## Comments on any other information and submissions received by D1 and D2

This document sets out the comments on any other information and submissions received by D1 and D2 not otherwise covered by other representations submitted to D3 by Cambridgeshire County Council (**CCC**), Huntingdonshire District Council (**HDC**) and South Cambridgeshire District Council (**SCDC**) (together, the **Councils**). Set out below is the relevant respondent and document reference number.

### Highways England – TR010044-000997 9.10 Junction Modelling Technical Note [REP1-030]

**Figure 3-1 : Grantchester Road - 2015 AM Southbound Traffic Distribution**

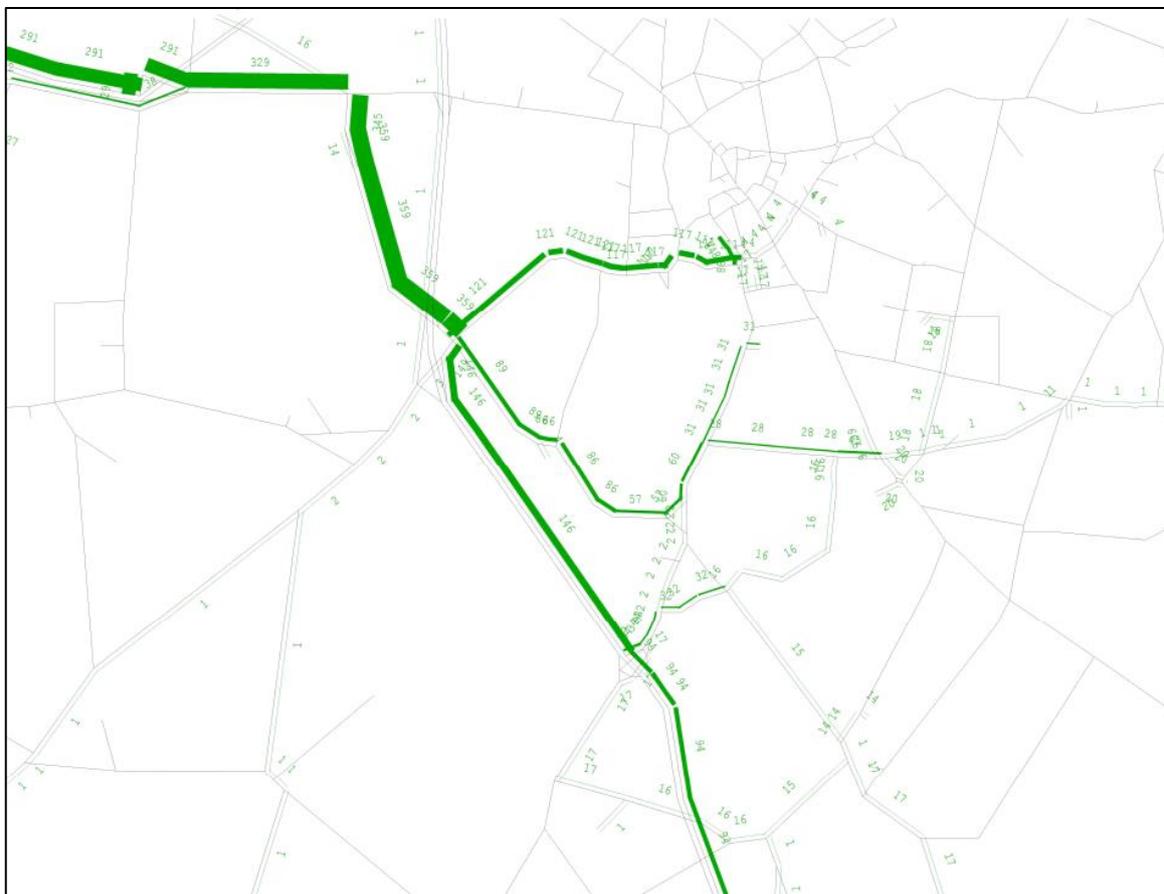
2.1.7 II.	<p><i>At the junction of Grantchester Road and the M11 J12 southbound off-slip, the turn saturation flow for traffic from the slip road is set too low.</i></p> <p>The Councils welcome the acceptance that the coding of this junction is wrong in the strategic model and this results in the incorrect performance off the road network being shown in this location. If the coding of the junctions in this section of the model cannot be redone to fix this issue that the Councils will require monitoring of this location to prove that the predicted model flows do not occur, and mitigation provided if they do.</p>
Traffic Origins and Destinations and Forecast Growth	3.1.1	<p><i>The fact that the southbound problem at Coton is due to insufficient capacity on the M11 J12 off-slip reduces the likelihood that the model is routeing longer distance traffic through Coton. Of the 360 PCUs [passenger car units] in the 2015 AM peak travelling southbound only 146 join the M11 at J12 and only 94 of these continue south of Junction 11 as displayed in Figure 3-1. Therefore, almost 75% of traffic in the model passing Coton in</i></p>

<p><i>the AM peak is traffic accessing the west and south-west areas of Cambridge and local villages.</i></p> <p>The origin and destination of the traffic using the roads through Coton is not the issue here. The issue is that the coding in this area of the model is wrong and this results in the incorrect performance off the road network being shown in this location. The result being that the performance of the local road network in this area is not reliable.</p>

**Figure 6-1 –Junction Models - Cambridgeshire**

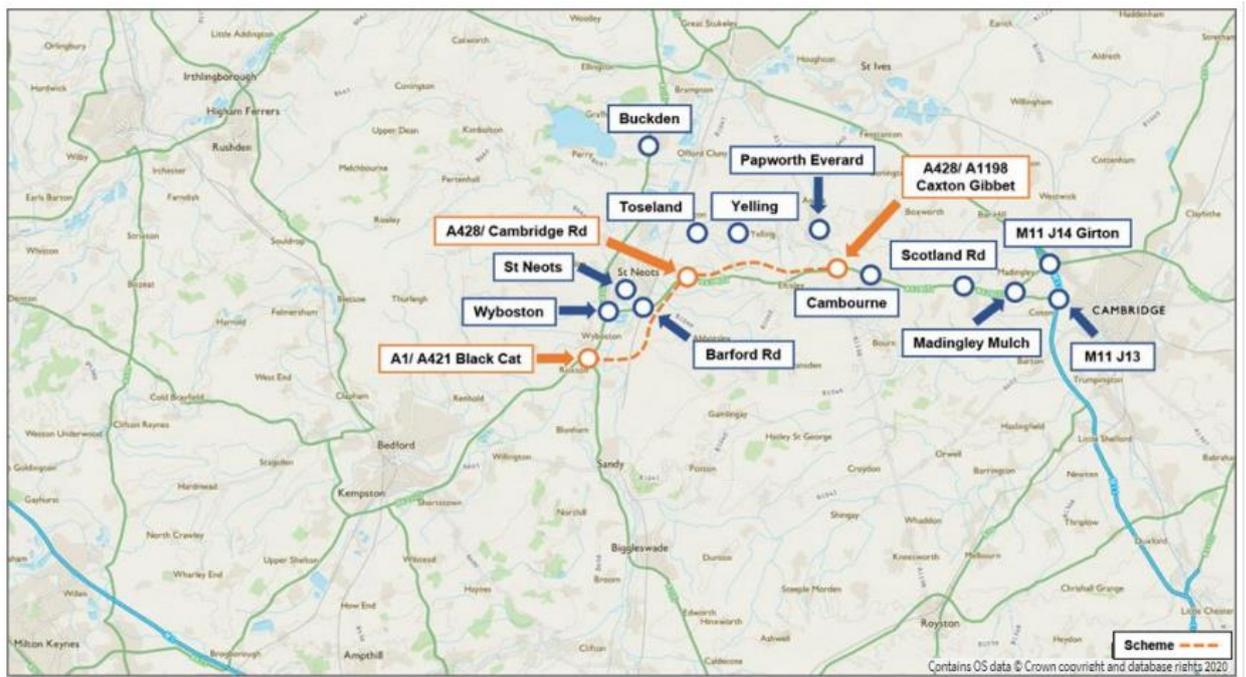
Topic	Paragraph Number	Comment
Junction Locations	Figure 6.1	Not all of the junctions listed in the text are shown on figure 6.1.
Scheme junctions	6.3.8	<p>The Applicant states that <i>“a comparison has been undertaken and which shows that the SATURN base flows (including HGV flows) are significantly aligned with the surveyed flows”</i></p> <p>Not all of this analysis has been provided to CCC. CCC wishes to discuss the detail of this comparison exercise with the Applicant.</p> <p>CCC understands that this only compares modelled &amp; NH’s observed flows at B1046/Potton Rd and one of the 2 Eltisley jns B1040 St Ives Rd/A428 CCC analysis of these 2 counts concludes that the counts are not sufficiently aligned with the modelled flows to justify the Applicant’s approach.</p> <p>Furthermore, CCC analysis of modelled vs observed counts at the remaining junctions, Black Cat, Caxton Gibbet and Cambridge Rd arrives at the same conclusion.</p> <p>The key differences are in turning movements at the junctions, although some link flows are not sufficiently aligned either. See the example provided in the LIR [REP2-003].</p>
